# **KIRKLEES METROPOLITAN COUNCIL INVESTMENT & REGENERATION SERVICE**

**DELEGATED DECISION TO DETERMINE PLANNING APPLICATIONS**

| Reference No:         | <b>2024/62/91472/W</b>                            |
| Site Address:         | 12, Edge View, Golcar, Huddersfield, HD7 4BZ      |

Description
PROPOSED LOWER AND UPPER FLOOR PLANS COMBINED

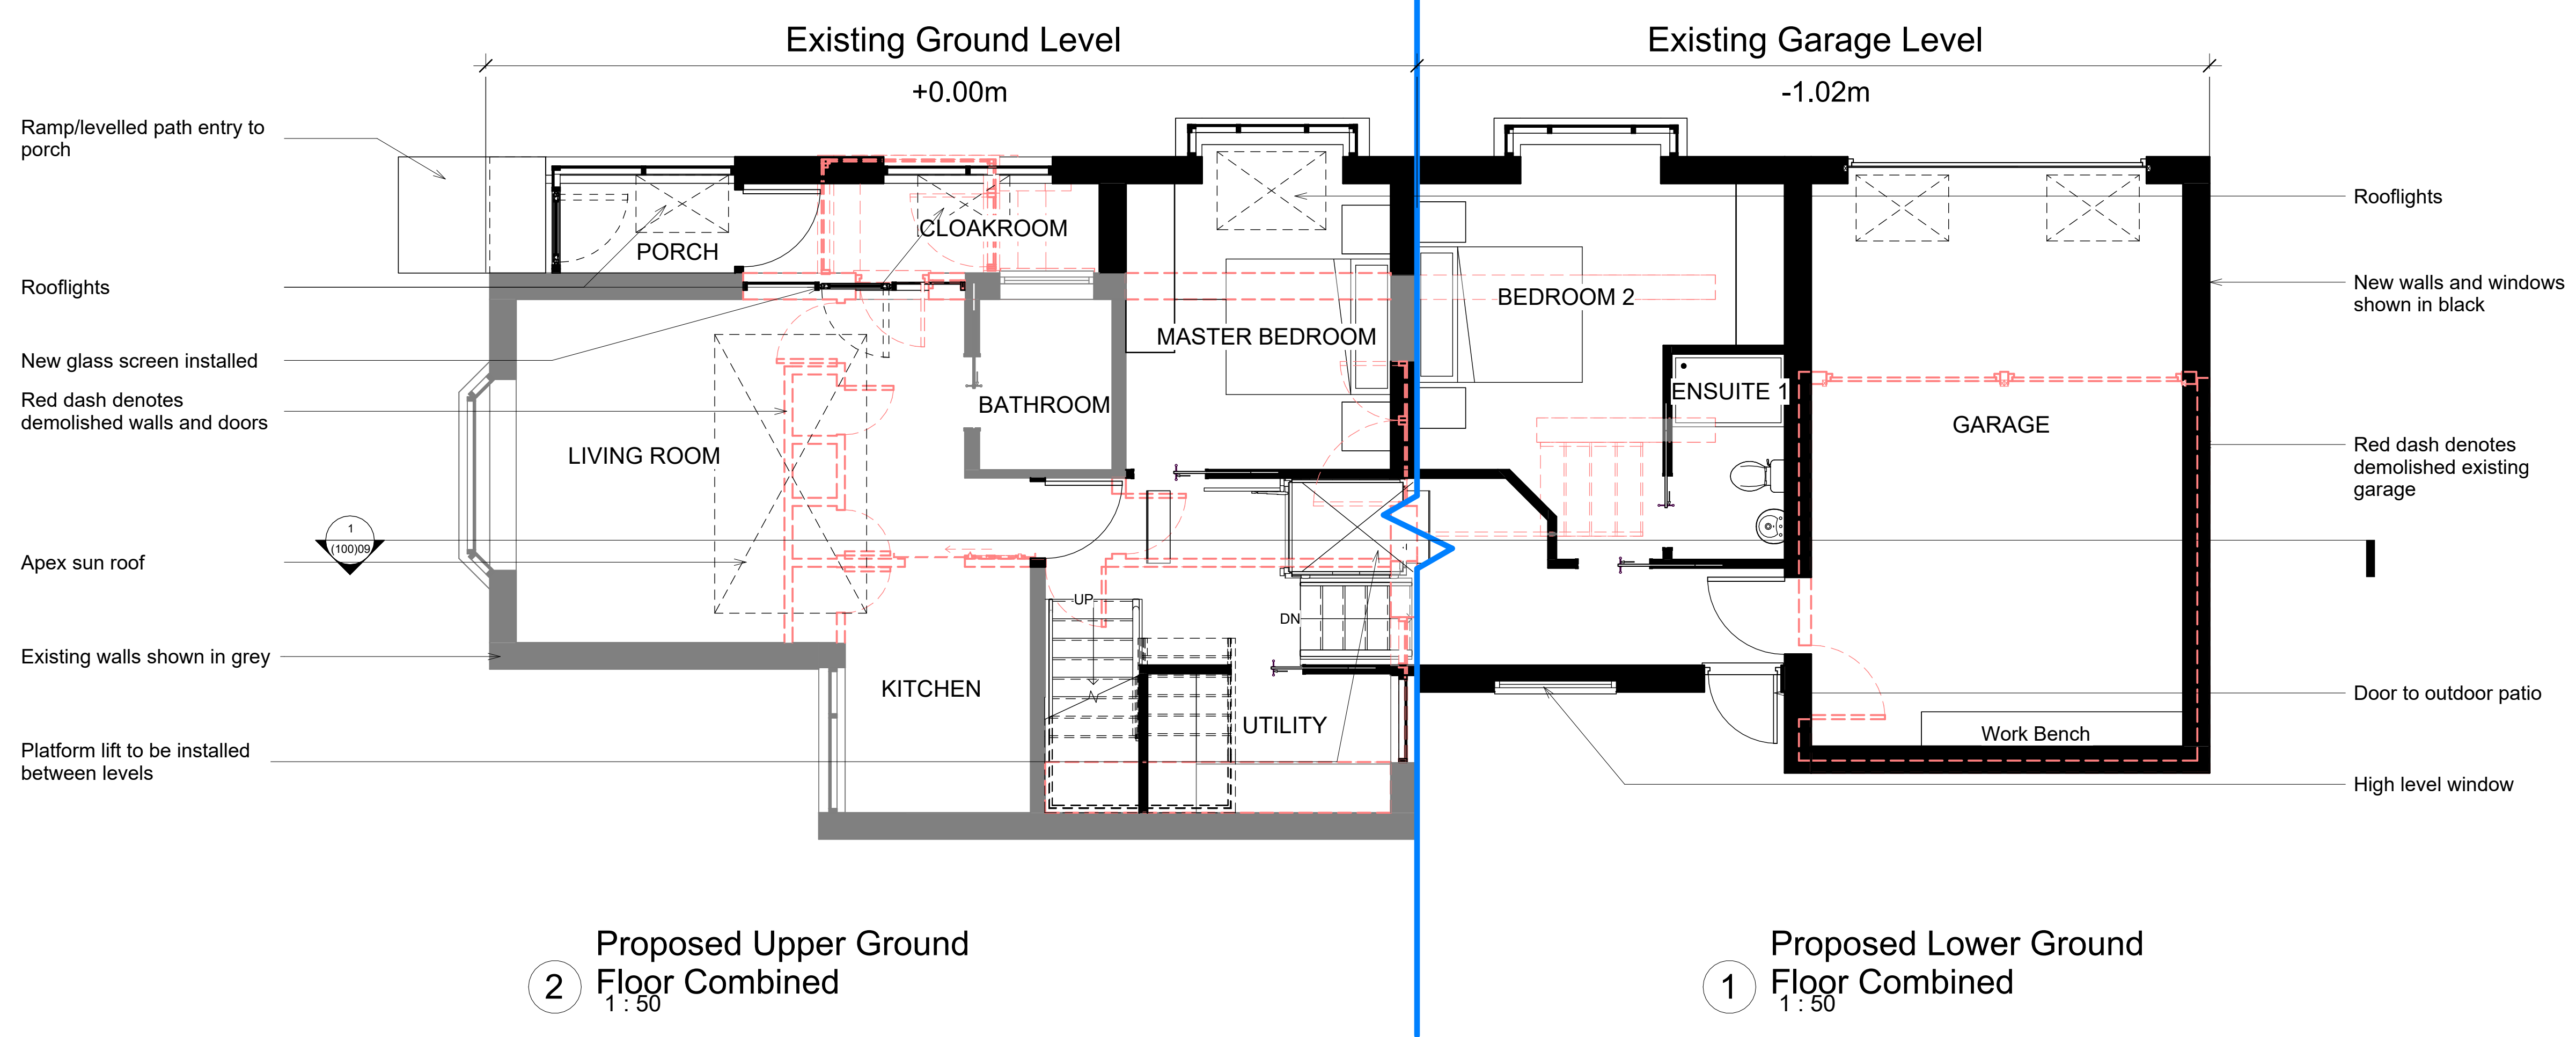
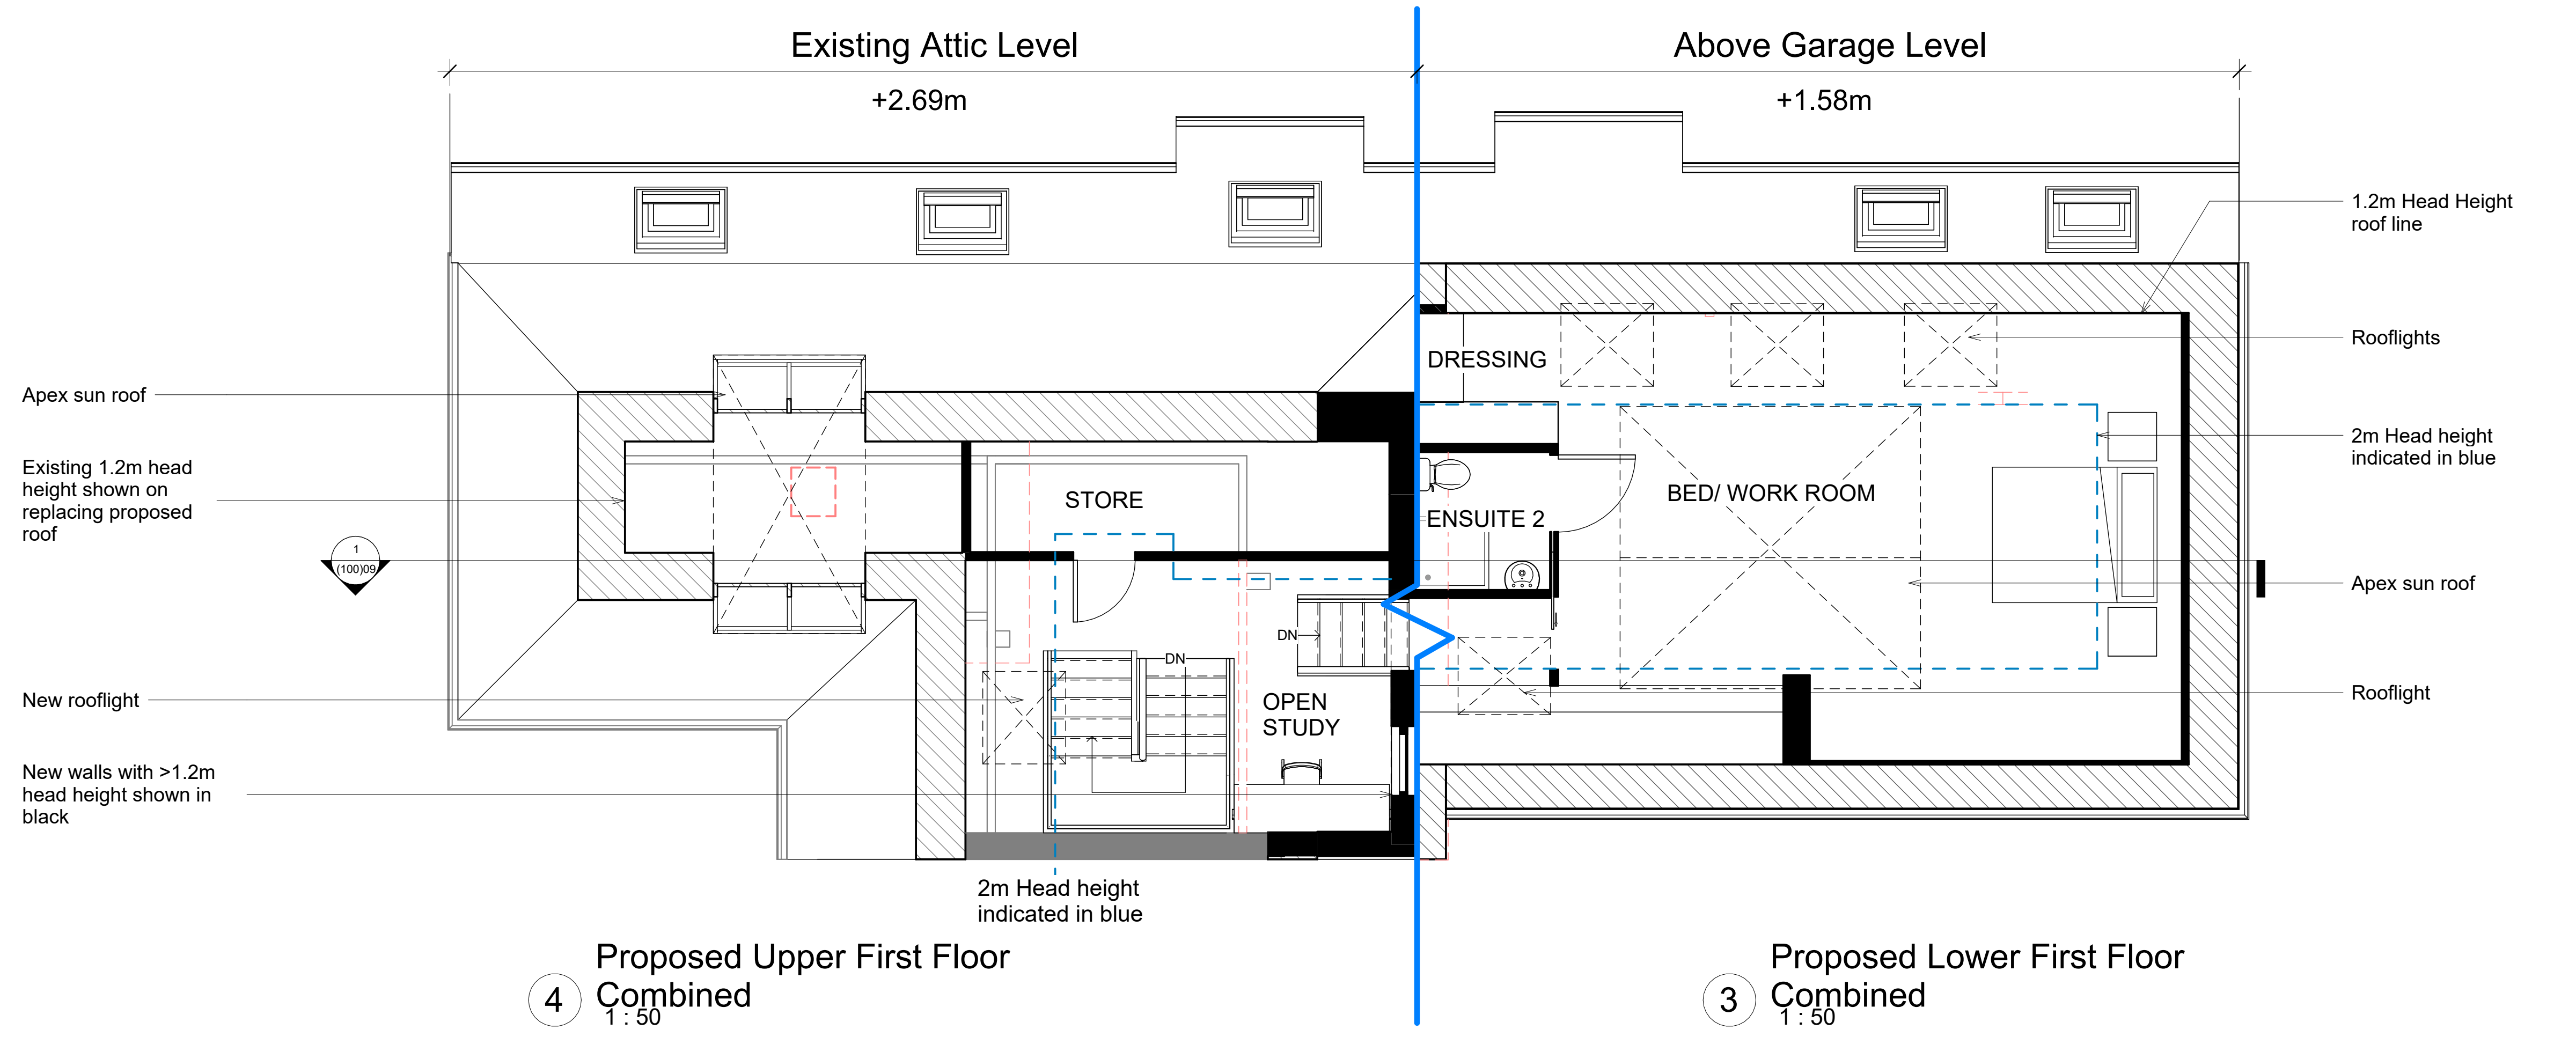
The two-storey extension proposed to the host property would not appear as a subservient addition, with the length of the host property measuring approximately 12.45 metres and the length of the extension meaning approximately 9.5 metres, meaning that the extension is greater in length than 2/3 the length of the host dwelling. In addition, the height of the extension would be significantly greater in height than the ridge height of the existing dwellinghouse. For these reasons, it is concluded that the two-storey extension proposed to 12 Edge View would present undue levels of bulking and massing, with the impacts of this exacerbated further given the prominent siting of this proposed extension within the site, visible from public vantage points.

Whilst officer's note the presence of dormers within the streetscene to neighbouring properties, it is considered that the erection of the dormer as proposed under this application would contribute to the incongruous appearance of additions to the host property, appearing as a contrived and cramped addition between the two roofing forms.

The proposed single storey flat roofed extension would span across the entire northern elevation of the property. Whilst officer's note the presence of a flat roofed porch to the existing property and similar features to neighbouring properties, particularly those along Edge View, these are of a smaller size/scale to that proposed as part of the development under this planning application.

The proposed two-storey extension would retain a separation distance of approximately 0.5 metres from the shared boundary and this extension would cut a line of 45-degrees across the entire rear elevation of No. 10 Edge View and beyond.

The proposal would see a significant level of bulk and massing along the shared boundary with no.10 and taking account of the size and scale of the extension it is concluded this would have a significant impact upon the outlook of the occupiers of no.10 as well as the levels of light to the openings within the rear of no.10.

Therefore, it is concluded that the proposed two-storey extension would result in undue levels of overbearing and overshadowing to the neighbouring property, as well as to the rear garden amenity space which serves No. 10.
